A303 Sparkford to Ilchester Dualling Scheme TR010036

8.1 Draft Statement of Common Ground with Environment Agency

STATEMENT OF COMMON GROUND

Version	Date	Status of Version
C01	July 2018	Application Issue
C02	December 2018	Working draft – for Environment Agency to review
Rev A	January 2019	Submission for Deadline 2

Location

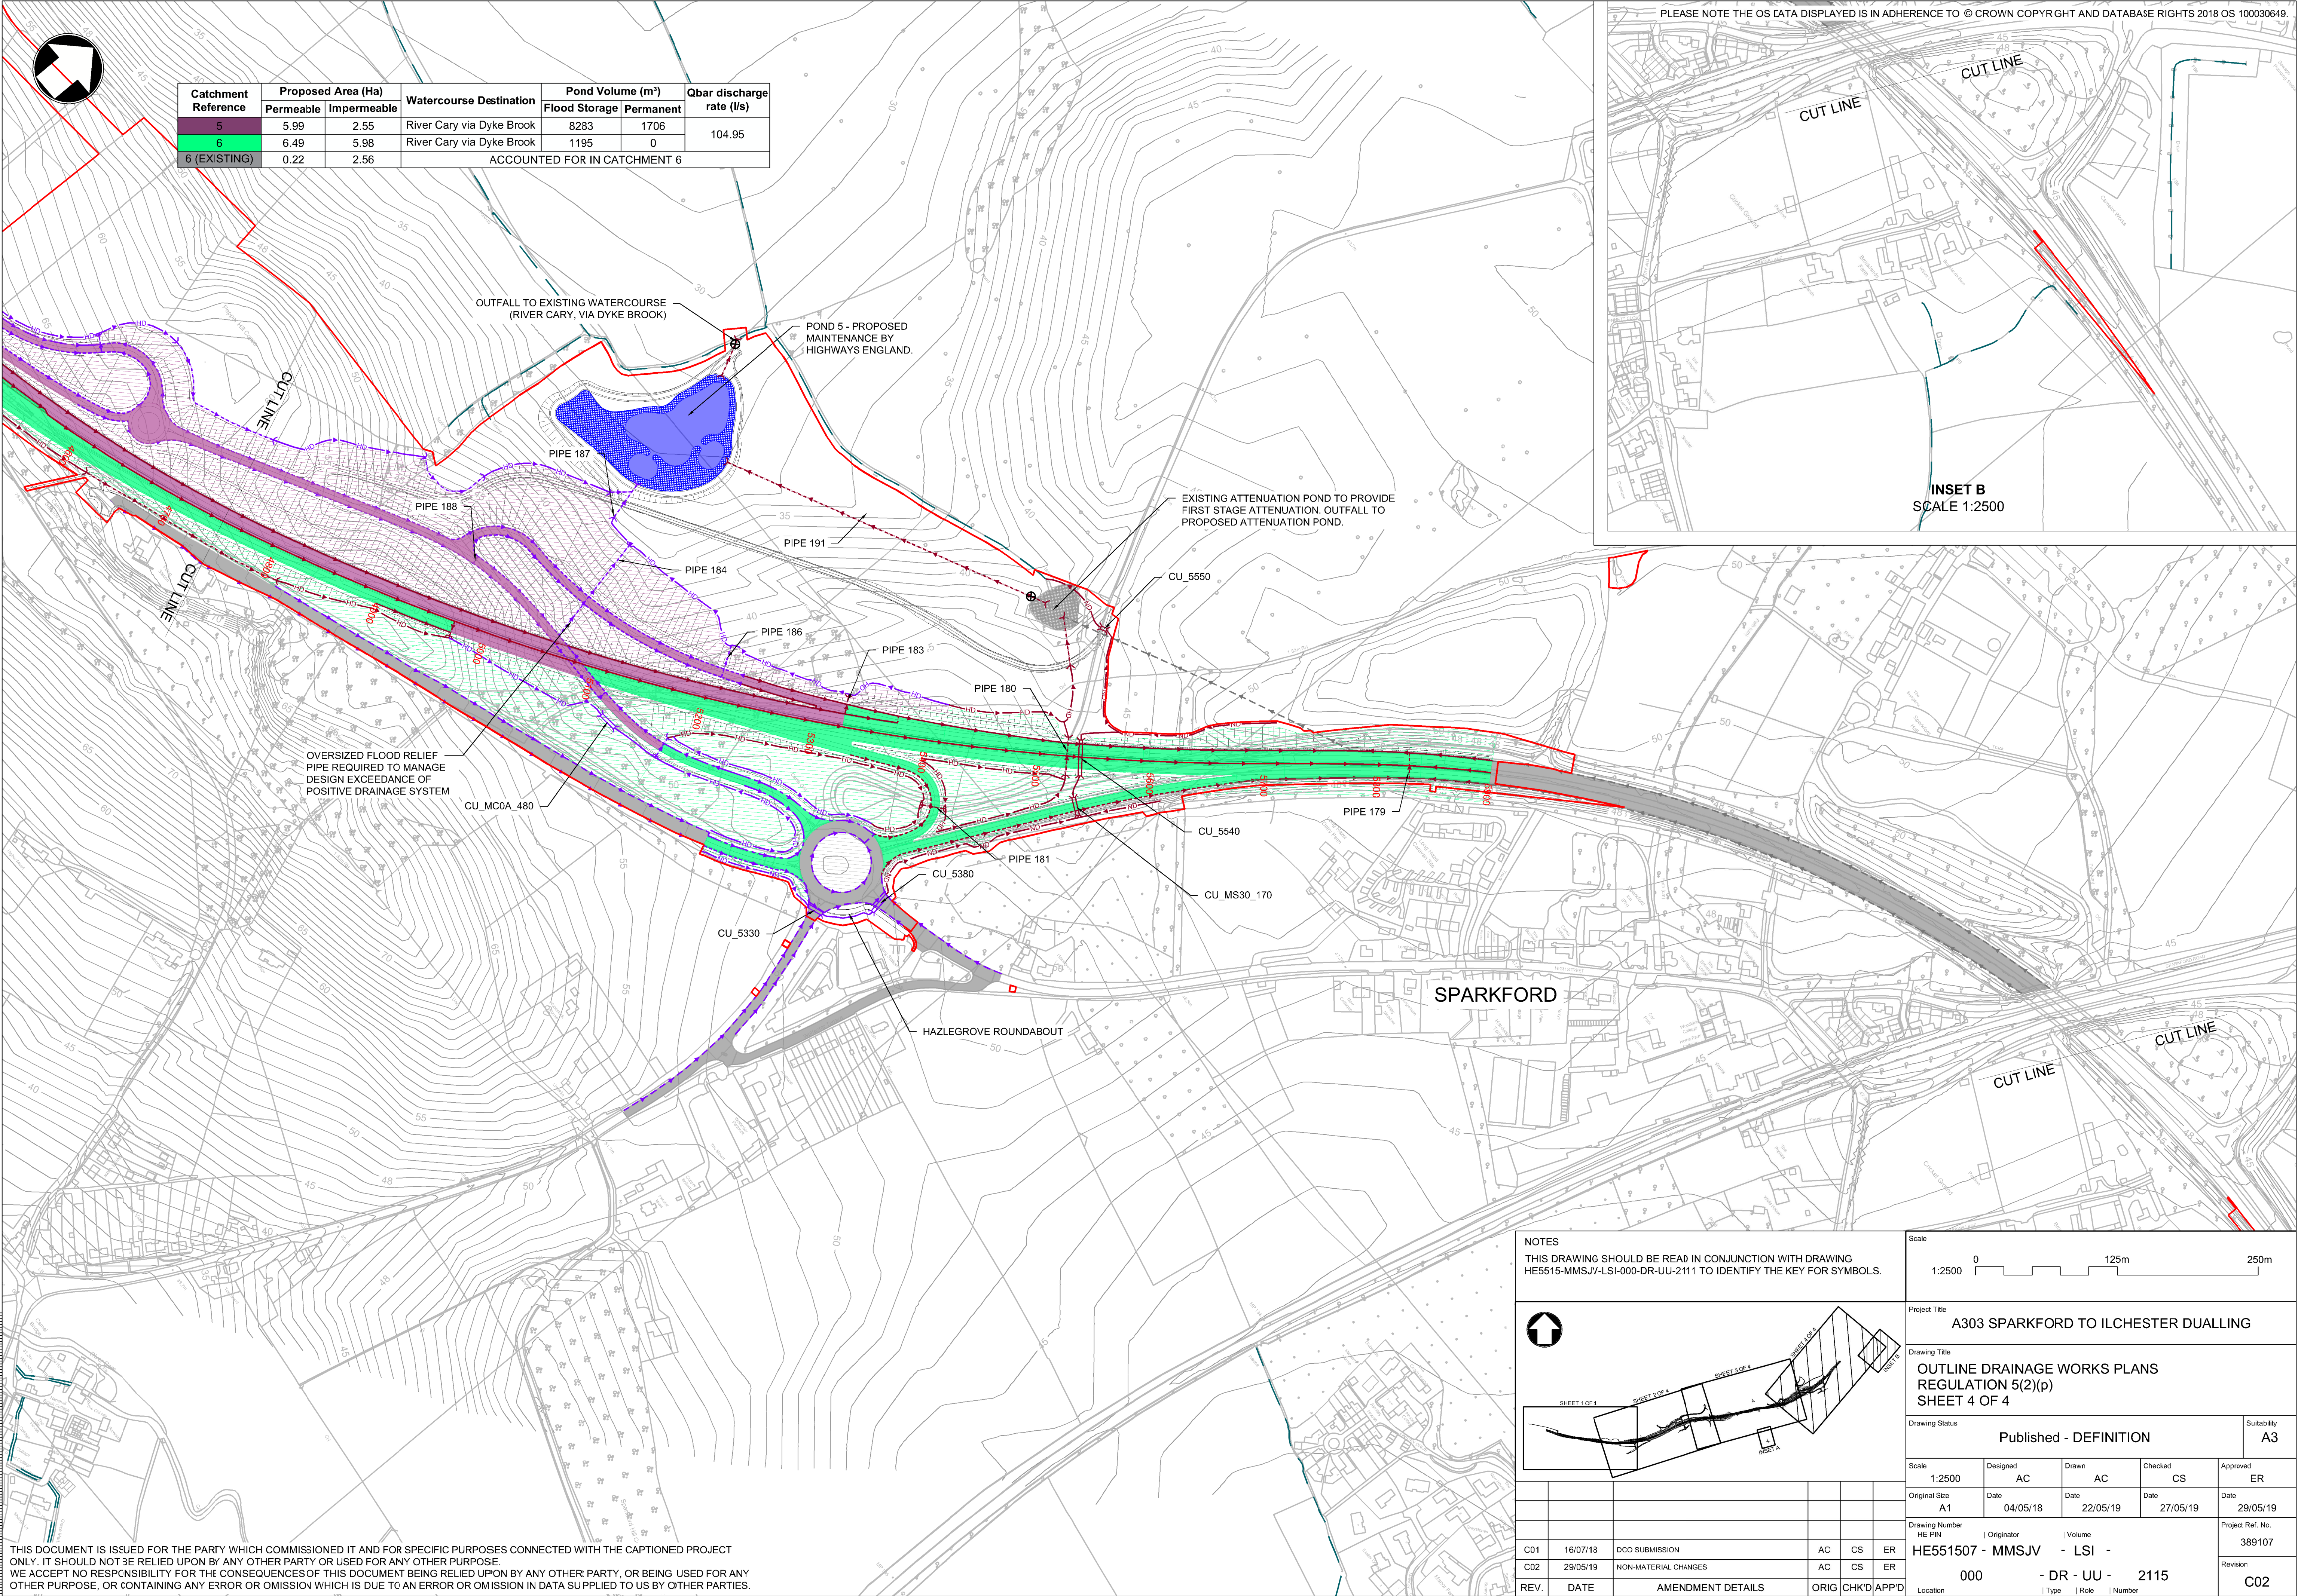
Topic	Sub-section	Environment Agency comment	Highways England response	Status
			Attenuation feature discharge rates and volumes shown in Outline Drainage Works Plans (TR010036/APP/2.11).	
		Confirmation is sought that the proposed design will control the overall volume, as well as the overall rate of runoff with sufficient attenuation provided.	Attenuation has been provided, with discharge limited to 1% annual exceedance probability (1 in 100-year event) plus 40% to account for the effects of climate change (Flood risk assessments: climate change allowances, Environment Agency), to no greater than the undeveloped rate of runoff, determined by the calculation of the mean annual peak rate of runoff for a greenfield site (Qbar). Preliminary design discharge rates and volumes shown in Outline Drainage Works Plans (document reference TR010036/APP/2.11).	AGREED <i>(see letter contained in Appendix A)</i>
